40 Northumberland Place, London W2 5AS
S73 Application – Amendment to application ref. 19/07849/FULL

This letter is written in support of an application for a minor material amendment to the approved scheme.

Project		40 Northumberland Place, London, W2 5AS		
Title		Proposed Sections AA		
Date	26.11.18	Scale [A3]	1:100	Drawing no.
				379-PL300
Rev.				3

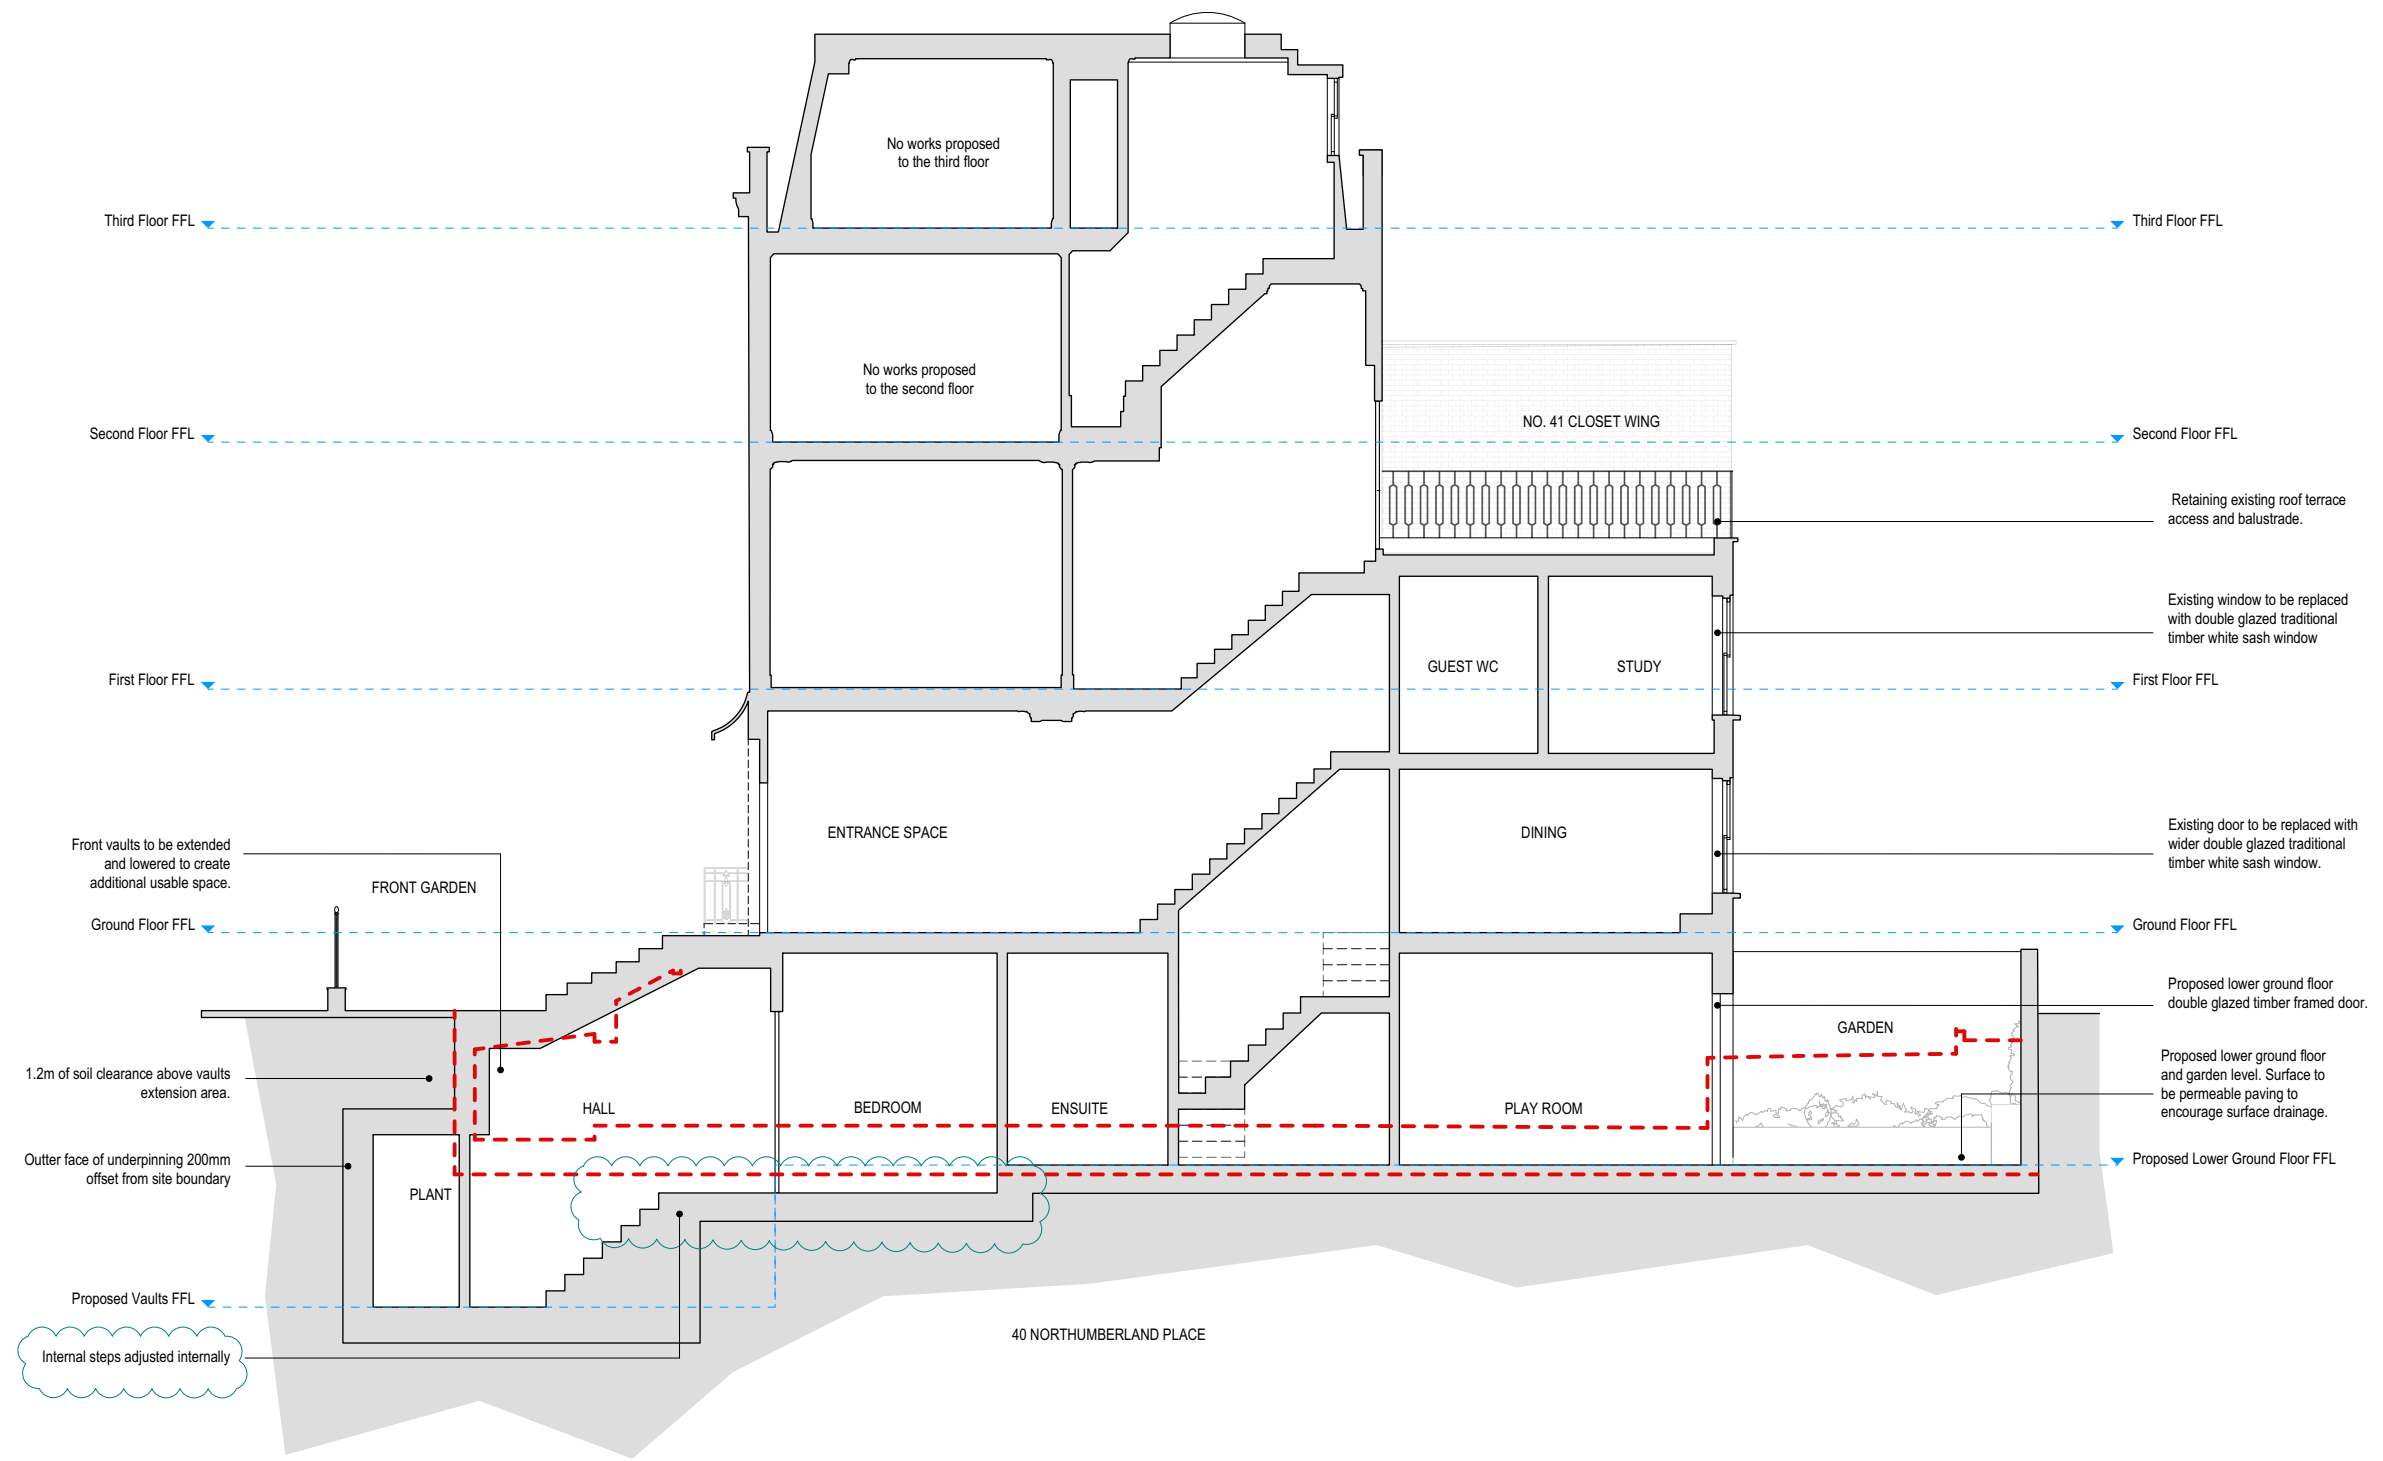
- Alterations to the front garden area including reducing the size of the lightwell, changes to the front entrance steps and repositioning of the bin store and planters;
- Changing the style of lower ground floor (secondary) front entrance door to include a fanlight;
- Rotating the rooflight to the glazed infill extension; and

- Adjusting the internal step arrangement to the lower ground floor and minor internal layout changes.
